Your ref:
Our ref: 22/01372/F
Please ask for: Miss Sandra Homcenko
Direct dial: 01553 616824
E-mail: borough.planning@west-norfolk.gov.uk

Details: **Demolition of single storey conservatory and construction of two storey extension and single storey porch. at 17 Low Road Roydon King's Lynn Norfolk PE32 1AN**

I have received a planning application as detailed above but cannot process it until I receive some more information:

SIDE ELEVATION AS PROPOSED
1/100

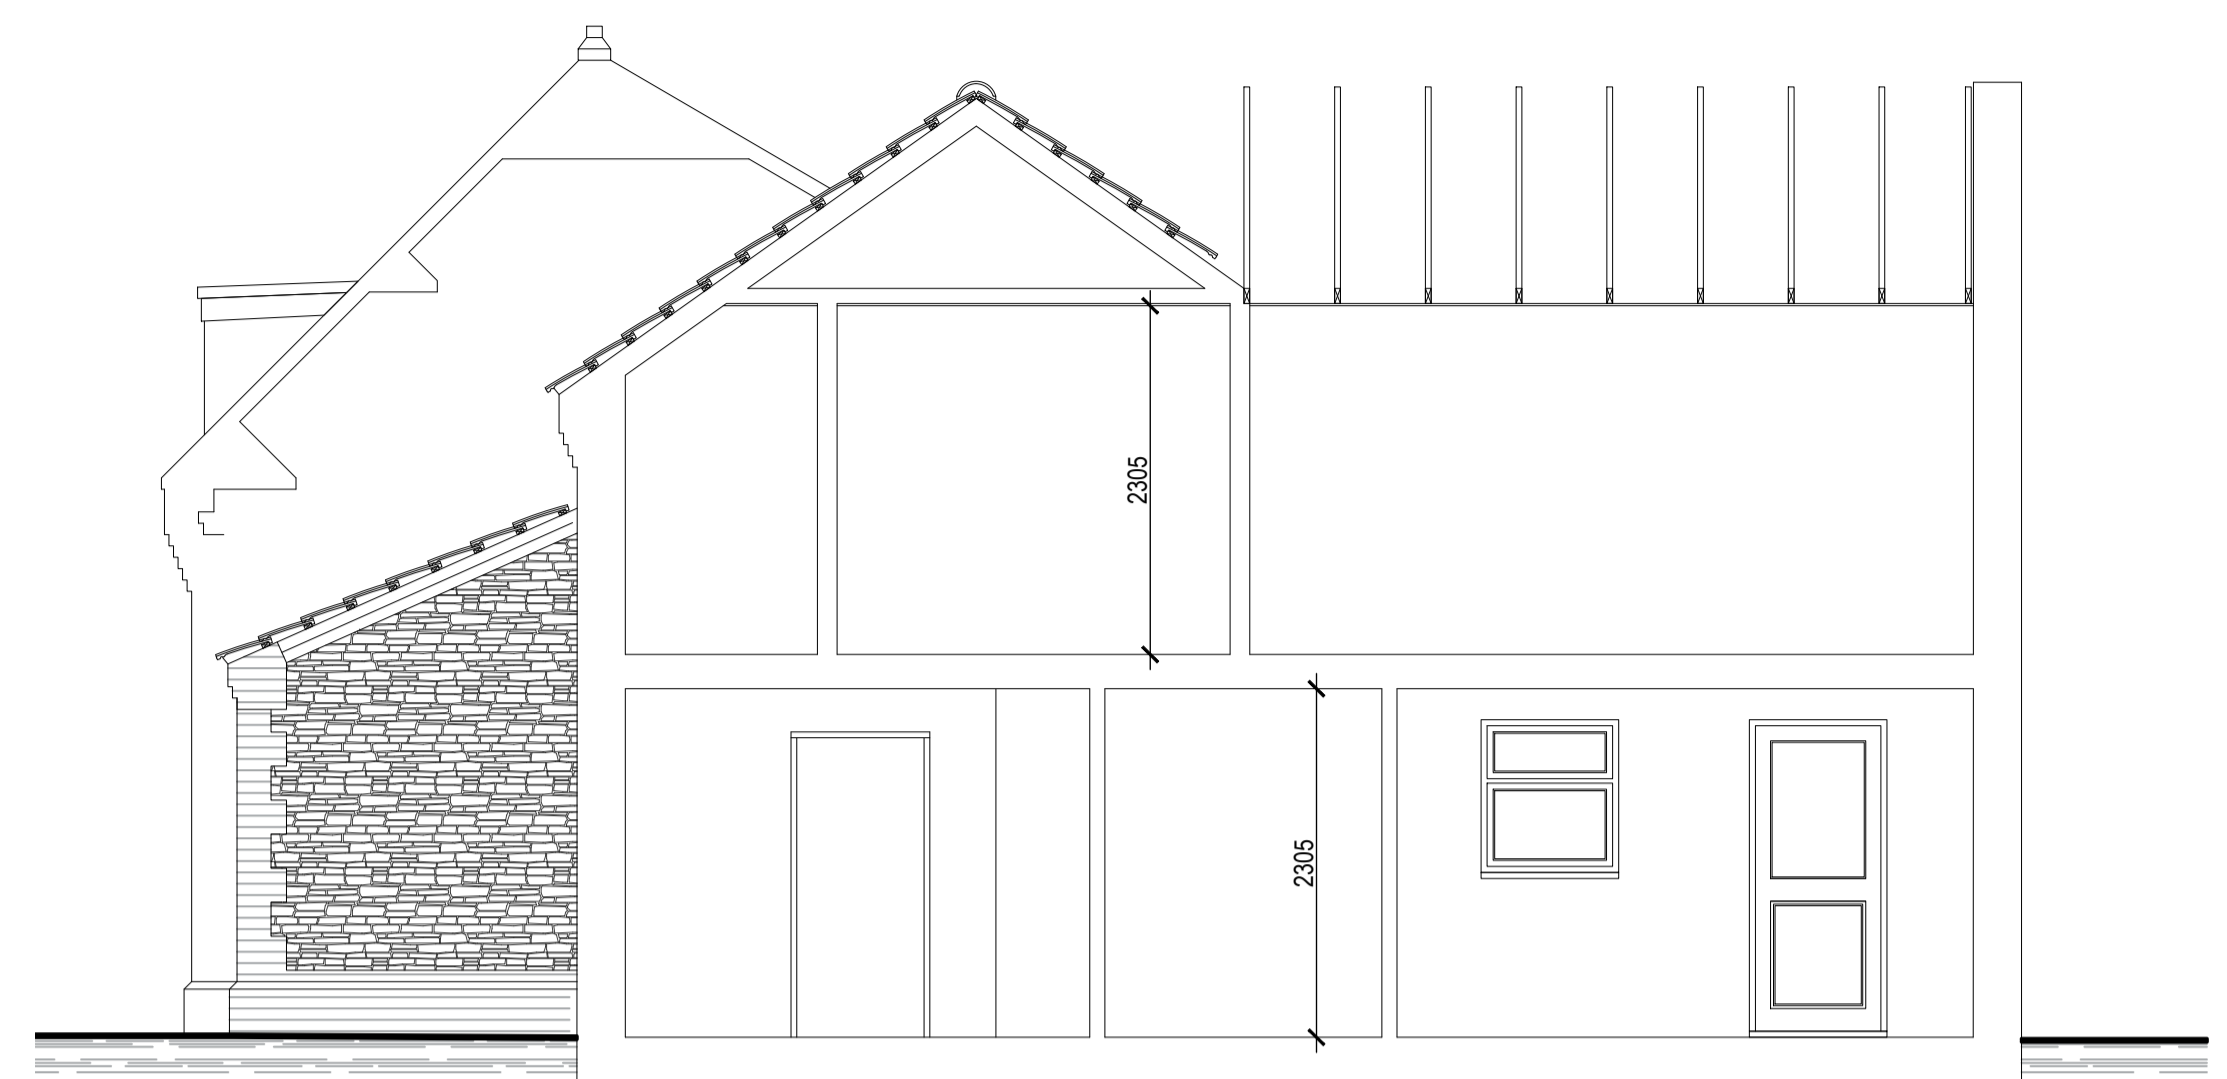
1. Please amend side elevation adjacent to neighbouring property on the proposed plans. It appears that the floor plans are missing window details.
